Subject: RE: BR/122/20/OUT Garth House, High Street, Bognor Regis

Further to my email of the 28th August, I have now had a better review of the application. I see that you are seeking outline permission with matters of layout and scale.

Proposed Ground Floor Plan

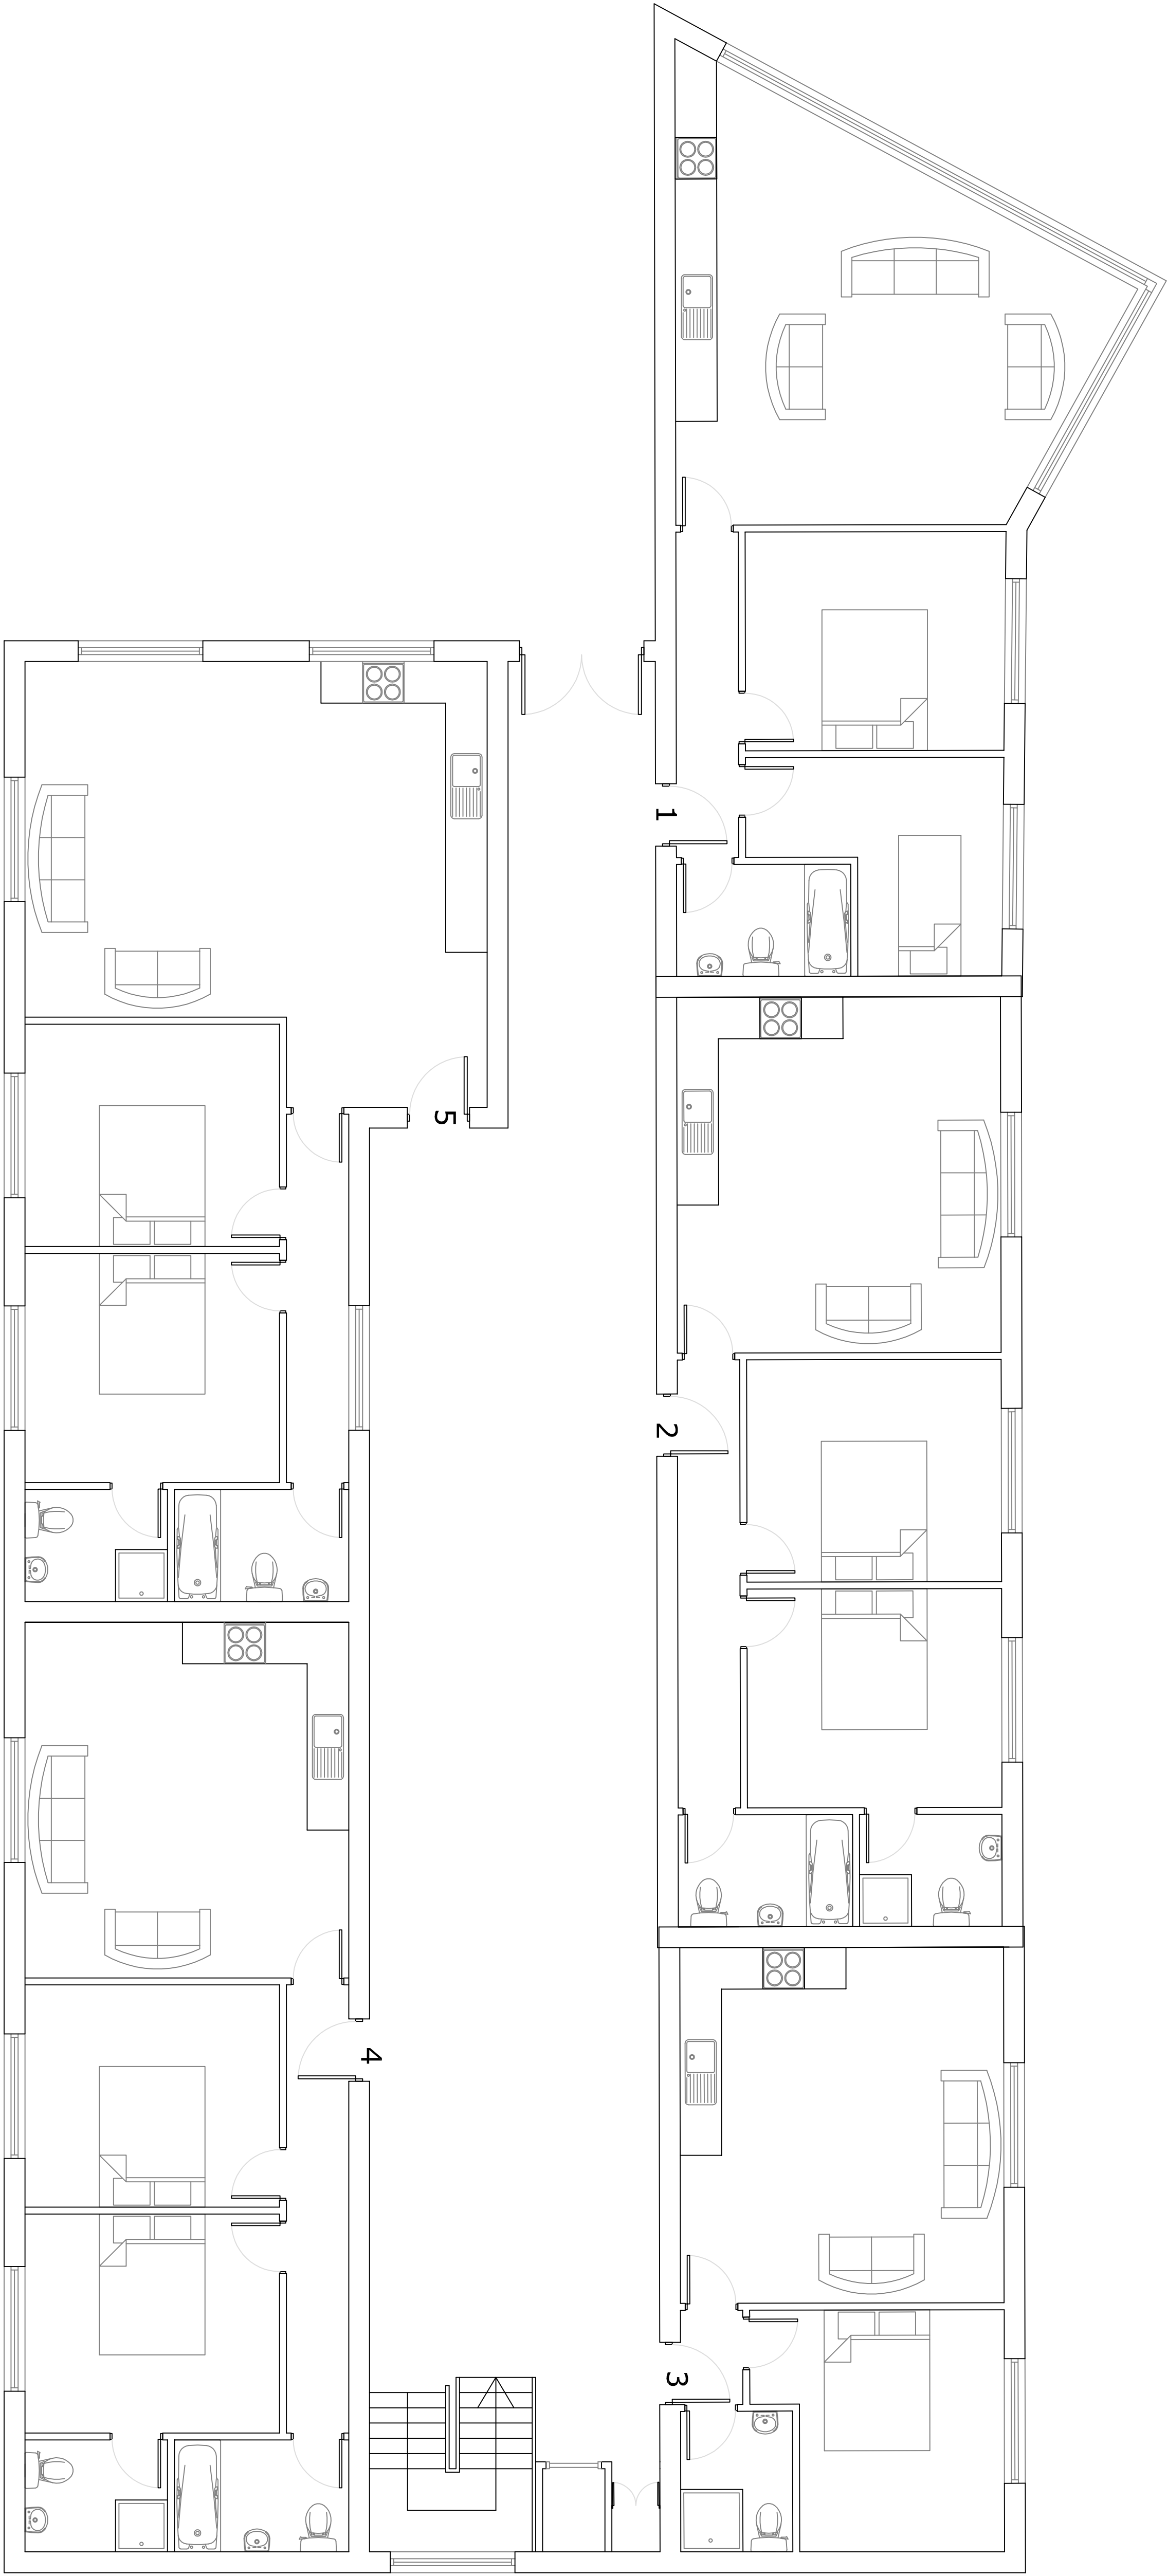
I do not think that the detail of layout is clear enough at this time and I would request that you submit a new layout plan showing the outline of the new building together with any details of parking, cycle storage, waste & recycling storage and amenity garden areas.

It would also be helpful to us if you can include neighbouring buildings on this plan or on a separate zoomed out plan so we can assess the impacts of the new building on adjacent properties.

Lastly, as you are not indicating any parking spaces (and do not have the space to provide sufficient to be in accordance with the requirements of our Parking SPD - <https://www.arun.gov.uk/download.cfm?doc=docm93jjjm4n14832.pdf&ver=15210>), then we will need from you a Lambeth Parking Capacity Survey to identify parking capacity nearby.
